October 2, 2013

Re: Bruckner's Truck Sales,
8101 Daytona Rd NW
Request for 30-day Temporary C.O. –Accepted
Engineer's Stamp dated: 9-20-12, (J09D021)
Certification dated: 10-1-13

Hydrology visited the site on September 25th, 2013 and found the following items to be addressed prior to release of Permanent Certificate of Occupancy:

18" SD HEAD WALL - SECTION A-A

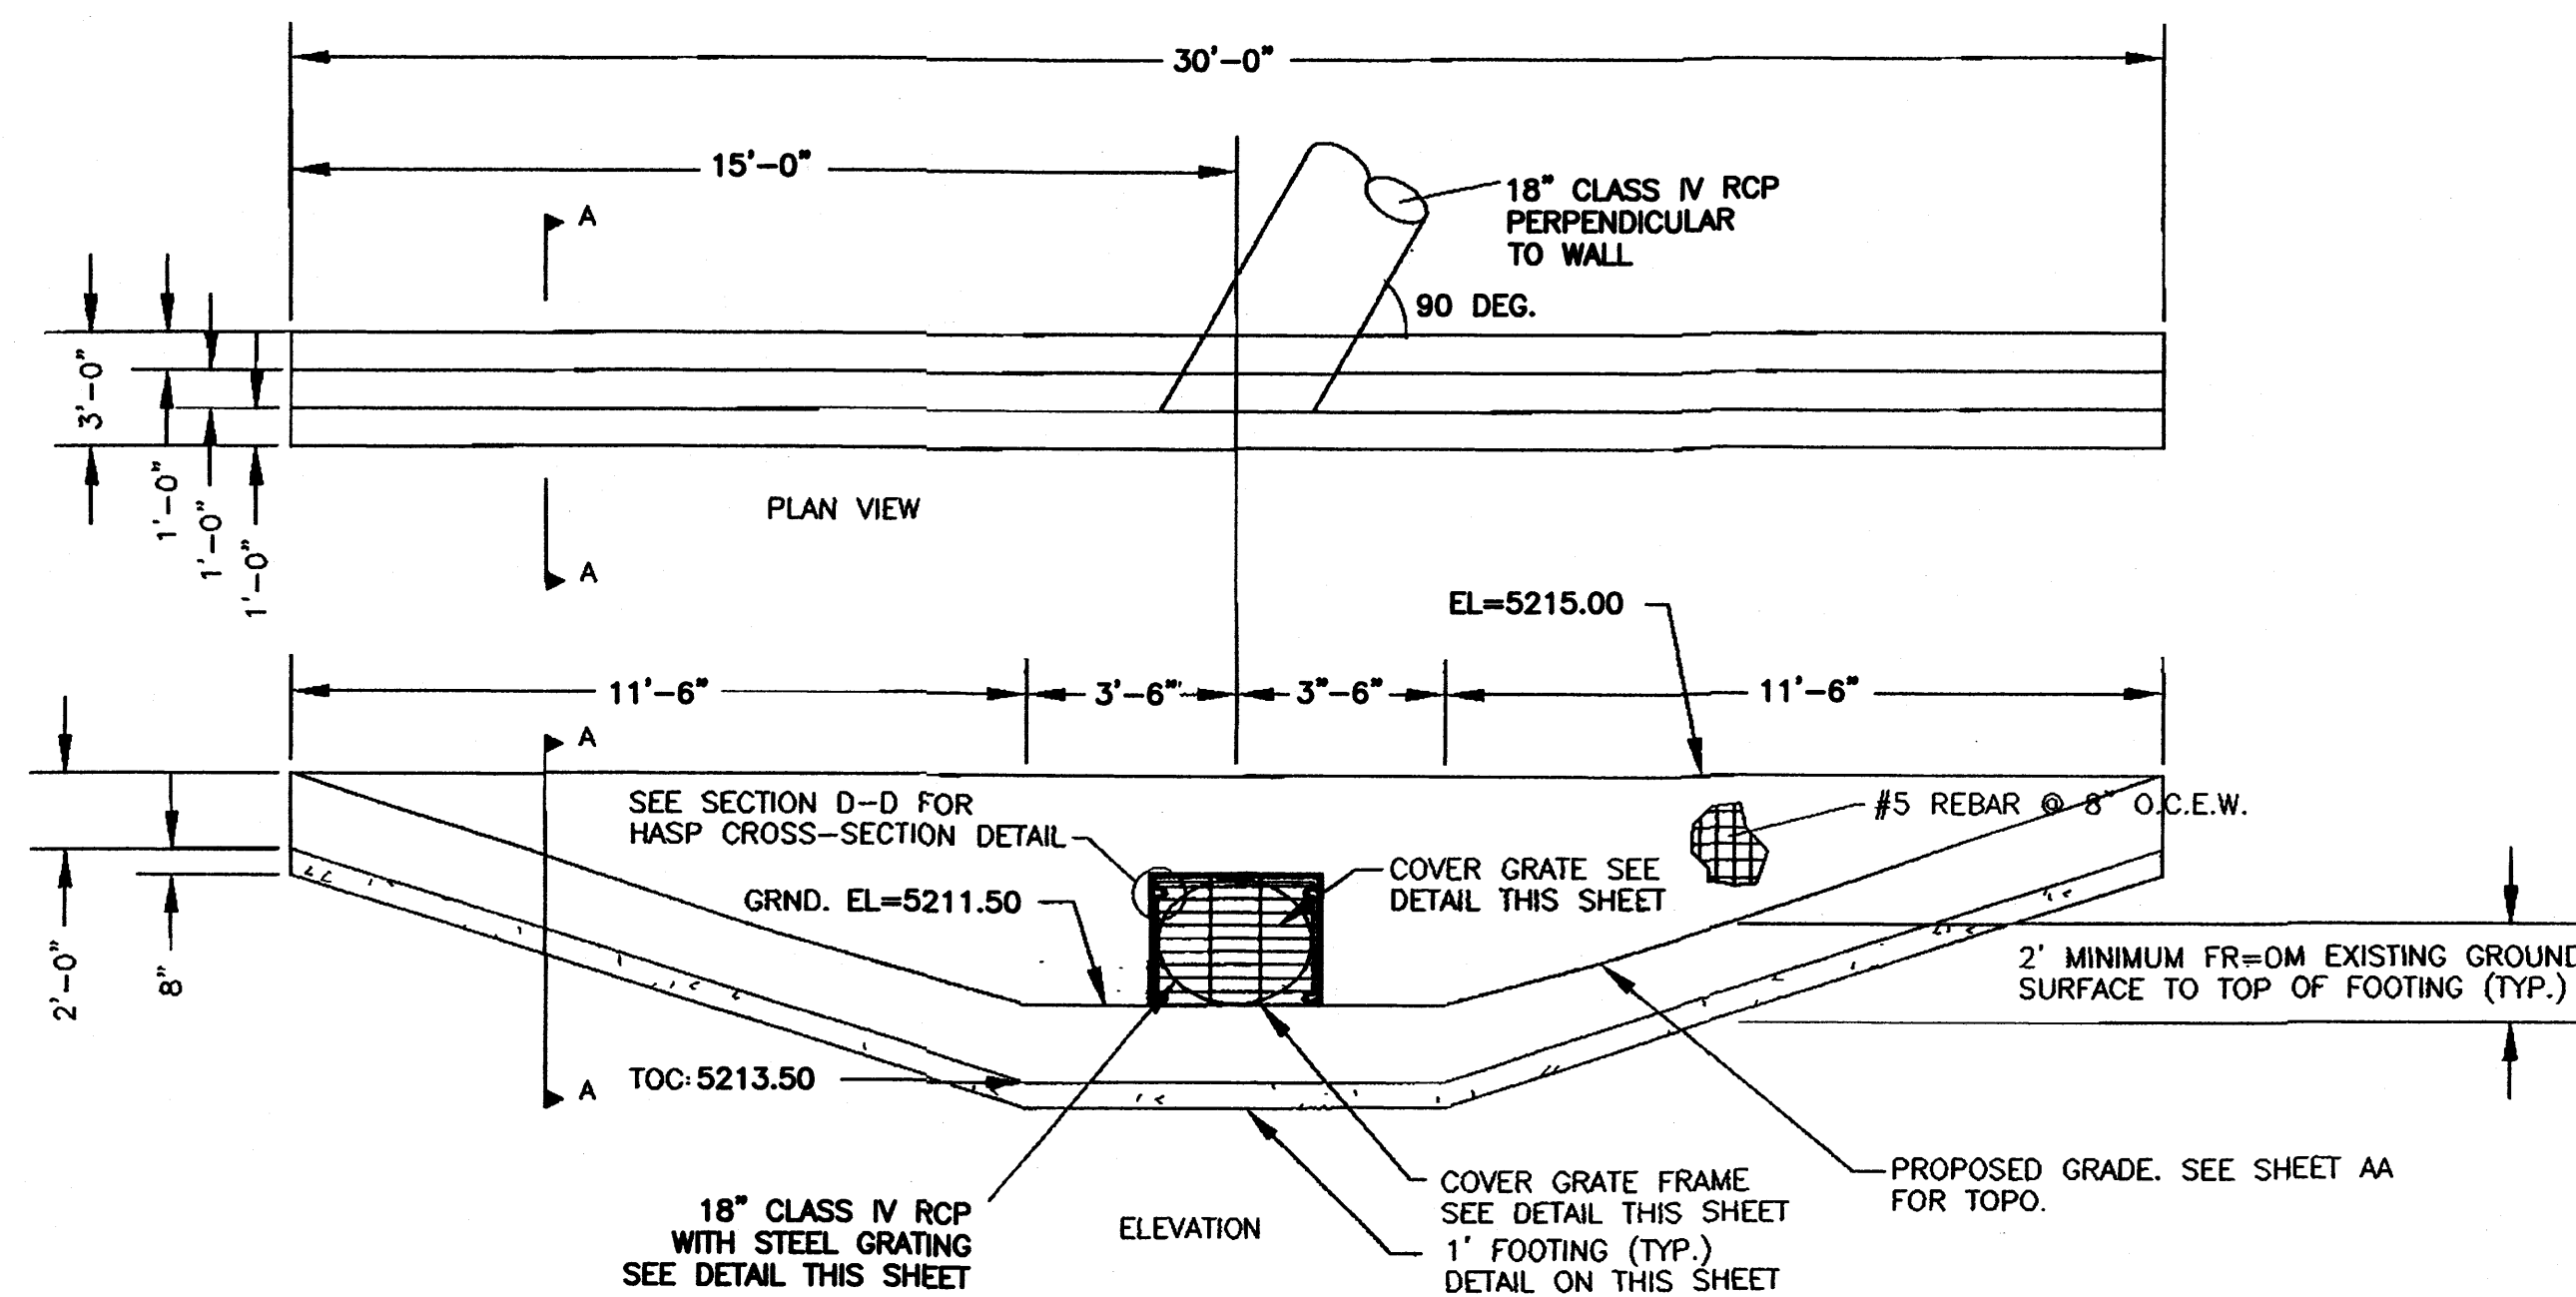
5. The 18" SD Headwall-Section A-A shown on sheet C8 was not visible at the Offsite Basin I40-3 location.
